Response to Referral – Fabcot- Shoalhaven Marketplace, Vincentia: Mod 5

Traffic Unit Comments

Prepared by Council Traffic Unit Manager, Scott Wells. 15 March 2013.

The following represents preliminary concerns regarding the new information submitted including new traffic impact assessment and new plans

Existing Saturday midday peak hour traffic flows plus Stage 1 development traffic

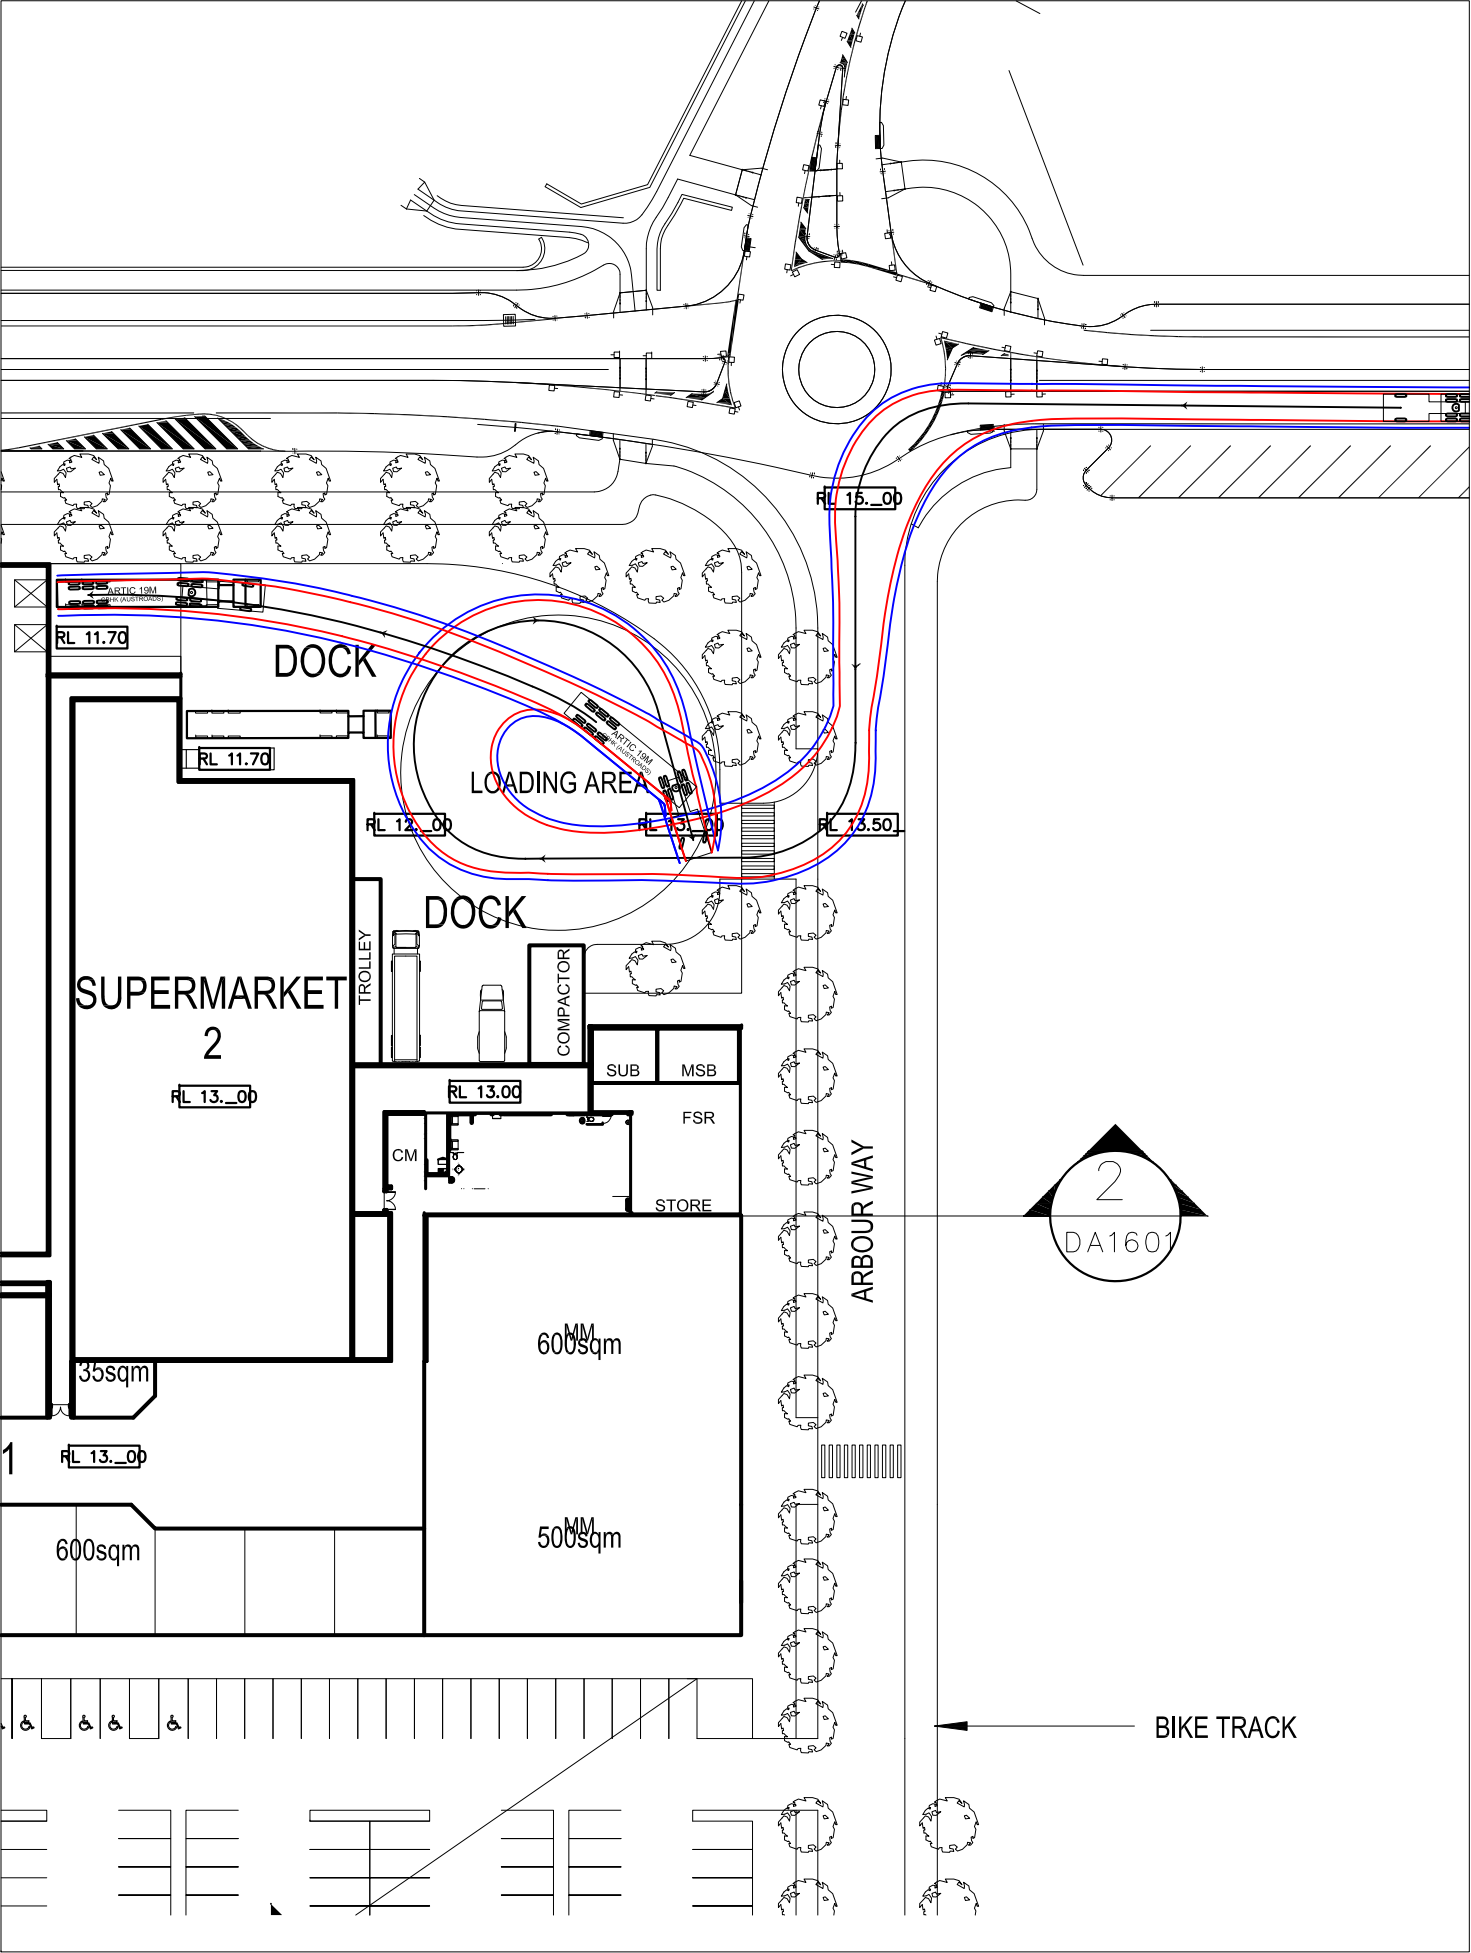
17. The existing + development flow diagrams (Figures 2 & 3 of the CBH&K Stage 1 report are incomplete), parts of Figure 3 of the CBH&K Stage 2 report also appears incomplete.

This diagram in the consultants report is incomplete (additional development traffic not shown on the surrounding network)

Sheet No. 1 of 16

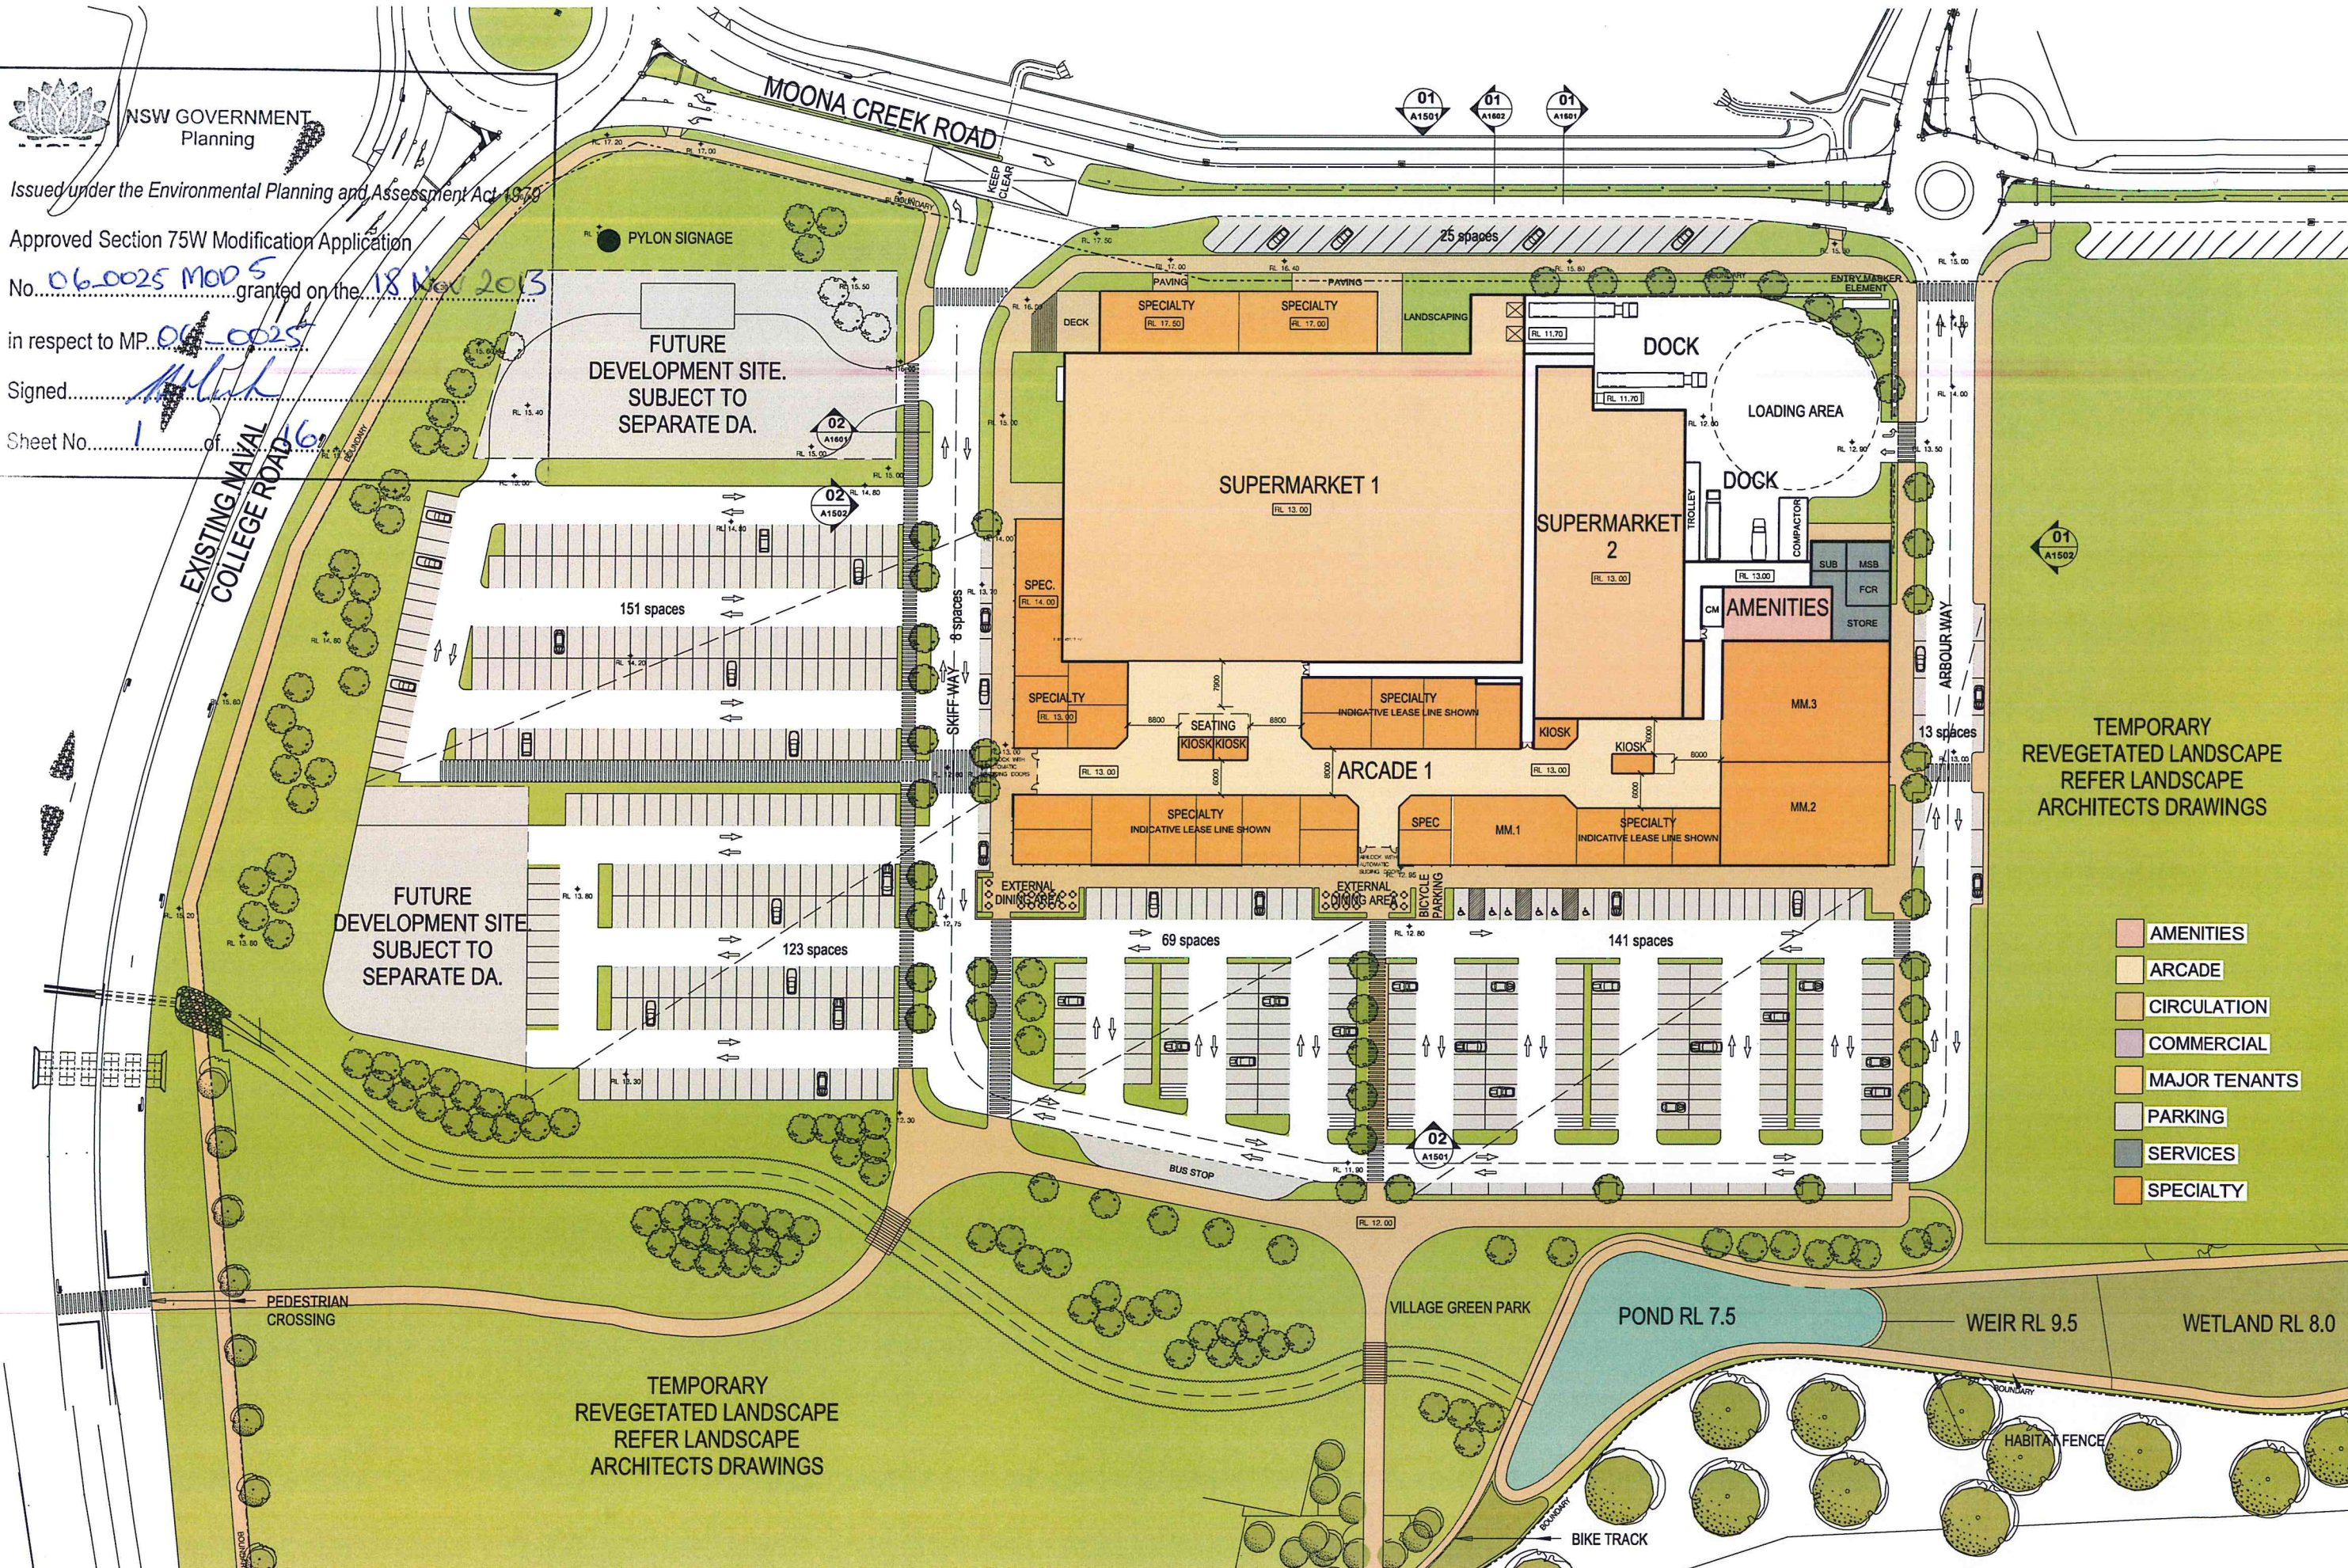
6. It is not accepted that the intersection of Moona Creek Road / Halloran Street become a 4 leg junction including access to a proposed new loading dock. For traffic and pedestrian safety reasons, and amenity of the development frontage; the intersection of Moona Creek Road / Halloran Street must be retained as a three leg junction. Service access should be via the far eastern roundabout.

10. Disabled car parking provisions are not satisfactory. Location of disabled parking must be as close as possible to all of the shopping centre pedestrian access points. It is not accepted that some general car parking spaces are closer to access points than some disabled car parking spaces. Further disabled parking numbers must exceed Australian standard requirements consistent with Council resolution (due to higher than average representation of aged population in Shoalhaven City). To comply with DDA requirements disabled car parking spaces should also be provided on Moon Creek Road in traffic units view. It is suggested that the angled spaces closest to Halloran Street could be converted in accordance with standards.

12. No pedestrian refuge has been shown in the median island at the car park entrance/exit to Moon Creek Road.
13. No footpath has been shown to the east of Halloran Street (south side), that is unacceptable. The footpath must extend to the eastern roundabout and link to pram ramps and refuges shown at that location.

14. It is not clear whether the fact that footpaths are not shown as shaded on the northern side of Halloran Street means they are not proposed? If so that is completely unacceptable. All works in the Moona Creek Road reserve including all road, footpath, intersection, and all associated works must be provided as per the latest version of design plans accepted by Council (subject to outstanding amendments). This includes all footpath connections to Halloran Street and Dinghy Street.

15. It is not clear what the intent of the indented bay is immediately to the south of Moona Creek Road? If that is proposed as a pick up/ drop off area, there must be an internal roundabout provided at the first internal intersection/access south of that location to facilitate safe and efficient turnaround of vehicles. The median island at the entry/exit would be required to be extended to the internal roundabout and pedestrian refuges provided at suitable locations to suit internal pedestrian desire lines.
